Ronald PUD FDP Compliance Review

Planned unit development of a two phased development of attached and detached residences at urban densities (ranging from a possible 30 to 238 units in Phase 1 and 12 to 100 units in phase 2), a possible hotel and active and passive recreation sites.

The Project received preliminary approval on September 7 16, 2011. Resolution No. 2011-009.

**Exhibit D-1
RONALD PLANNED UNIT DEVELOPMENT
REZONE 07-17
ORDINANCE NO. 2011-009
FINAL DEVELOPMENT PLAN
AUGUST 10, 2021**

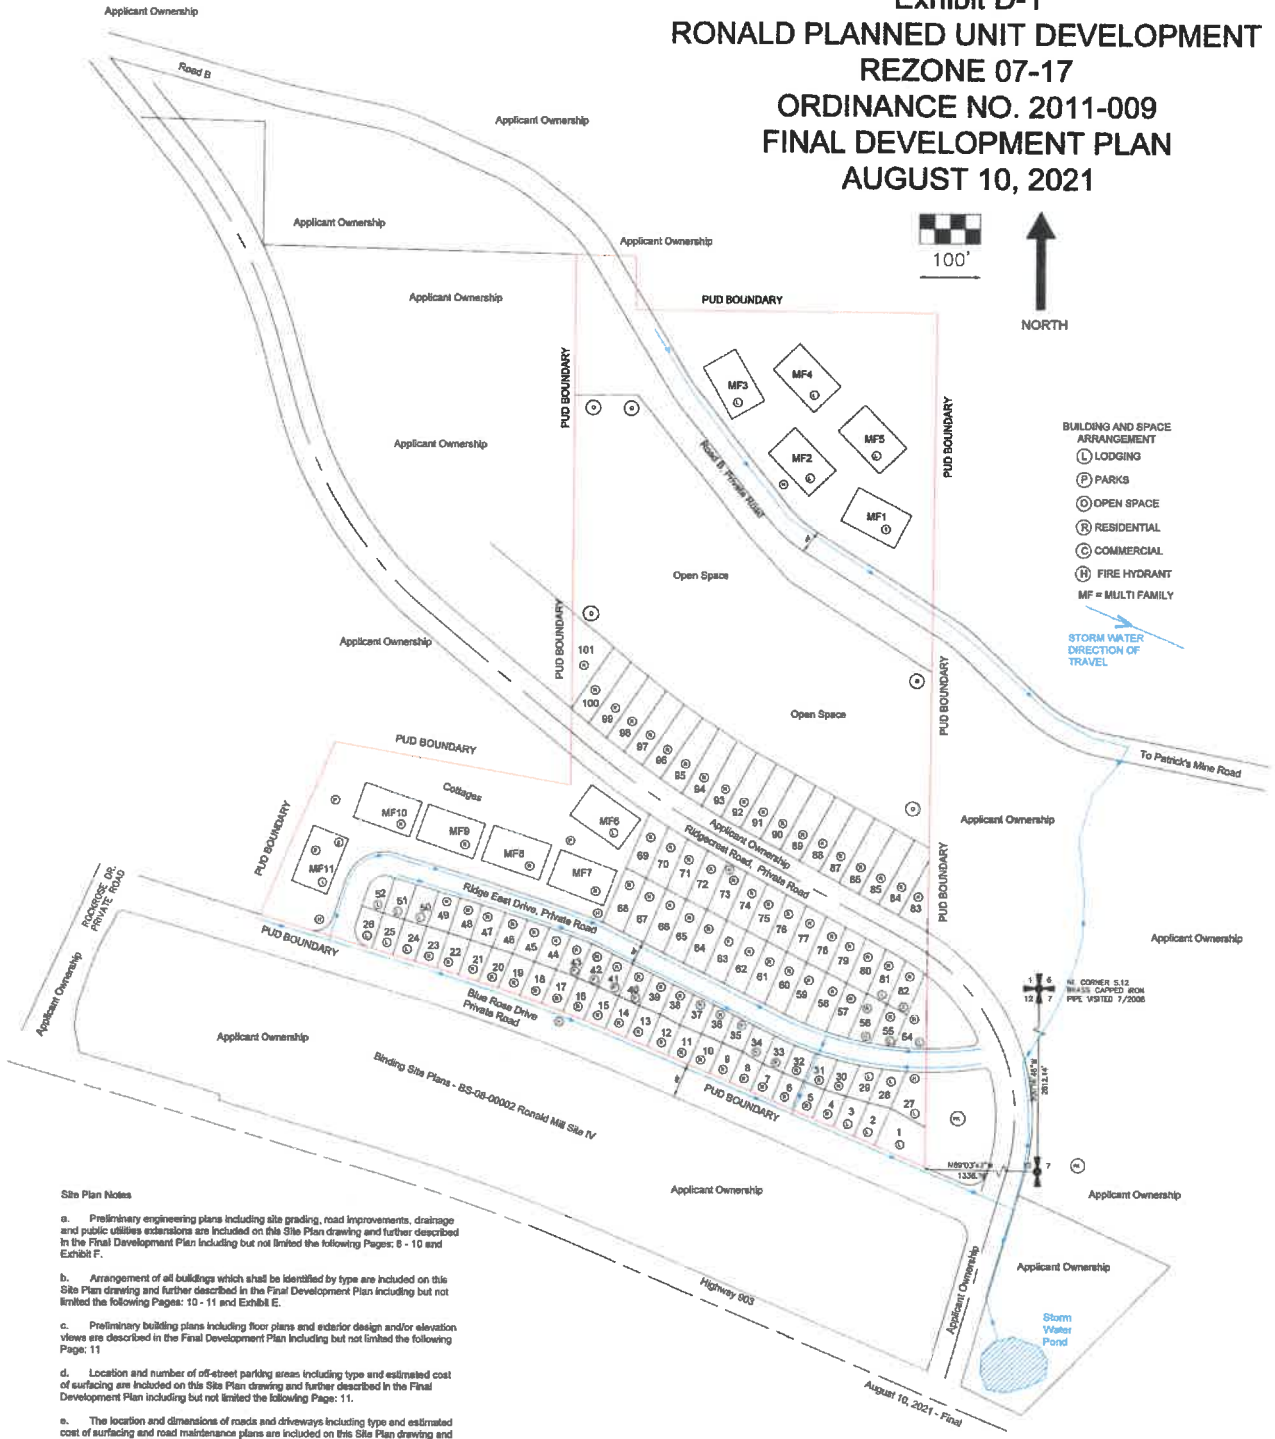
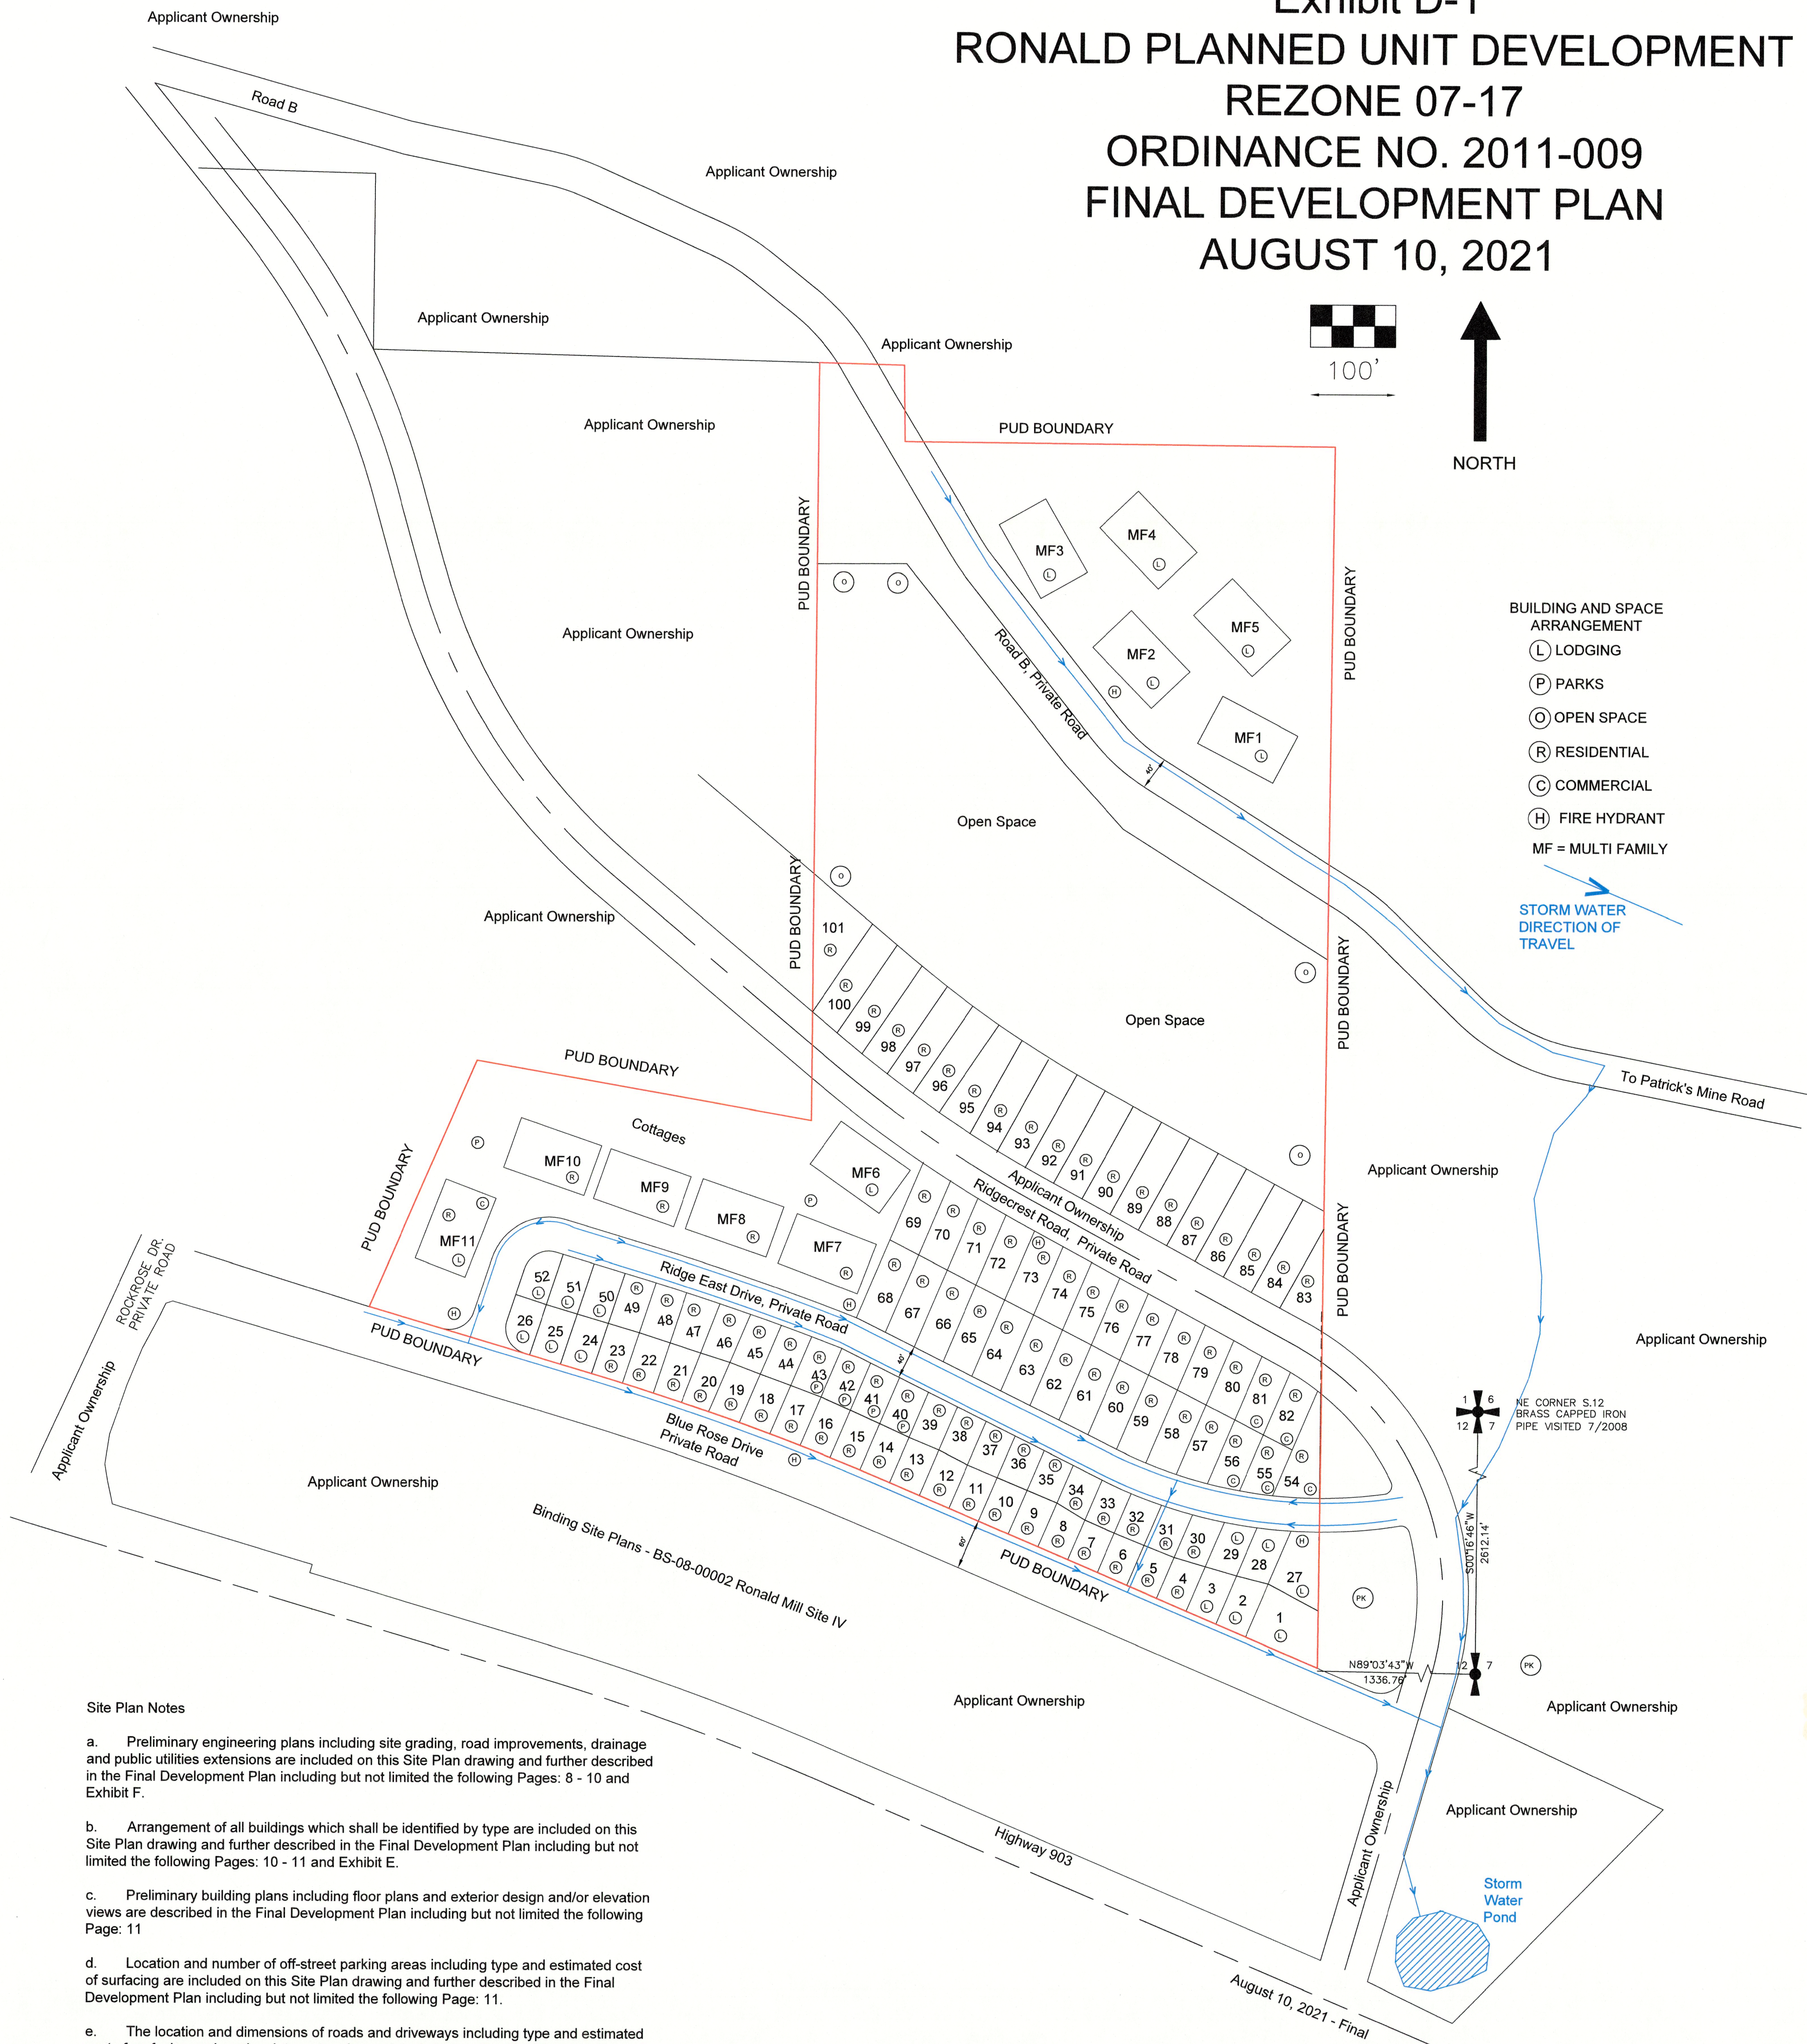
A.	RELEVANT CODE SECTIONS	ANALYSIS	FINDING
A.4	Provisions to assure permanence and maintenance of common open spaces;	Open space location is shown in Exhibit D1 and D2. The applicant states that all common open spaces transfer any required open space to Roslyn Ridge Recreation, LLC for ownership, or successor organization. The applicant states that The Activity Center at Roslyn Ridge Inc. or its successor organization shall manage this open space and other recreational opportunities within the PUD. This will need to be expressed as a plat note for final plat.	
A.5	Statement of intent including estimated cost for landscaping and restoration of natural areas despoiled by construction including tree planting. “Great care will be taken by the applicant in regards to the construction of the roads and infrastructure. Where practical all utilities will be placed within the road right of way. The applicant is estimating a cost of \$2.50 per lineal foot of developed road for restoration of areas distributed by construction activities and for landscaping.”	Applicant states all utilities when practical will be placed within the road ROW’s. An estimated cost of \$2.50 per lineal foot of developed road is anticipated for restoration of areas disturbed by construction activities and for landscaping.

B.11	All development shall conform to Kittitas County Road Standards. The Department of Public Works shall review all future development related to this PUD for conformance with Kittitas County Road Standards, current edition at the time of development. Roads must be built per Public Works requirements or bonded for prior to the issuance of a building permit.	Ronald PUD states they agree and will meet this condition.	
B.12	Private road design requirements shall be determined by the number of lots and/or units served, as determined by the County Engineer.	Ronald PUD states they agree and will meet this condition.	
B.13	On-site storm water management that conforms to the specifications of the most current version of the Stormwater Management Manual for Eastern Washington is required of this development. Stormwater systems shall be designed to store stormwater generated by a 24-hour, 25-year storm event. Stormwater system designs shall be prepared and stamped by a civil engineer licensed in the State of Washington. The stormwater system construction and a copy of the design shall be included with the road certification and is required prior to the issuance of a building permit. The stormwater system may also be bonded for as provided in KCRS 12.01.150.	Ronald PUD states they agree and will meet this condition. No documentation was provided for stormwater management other than location of stormwater pond.
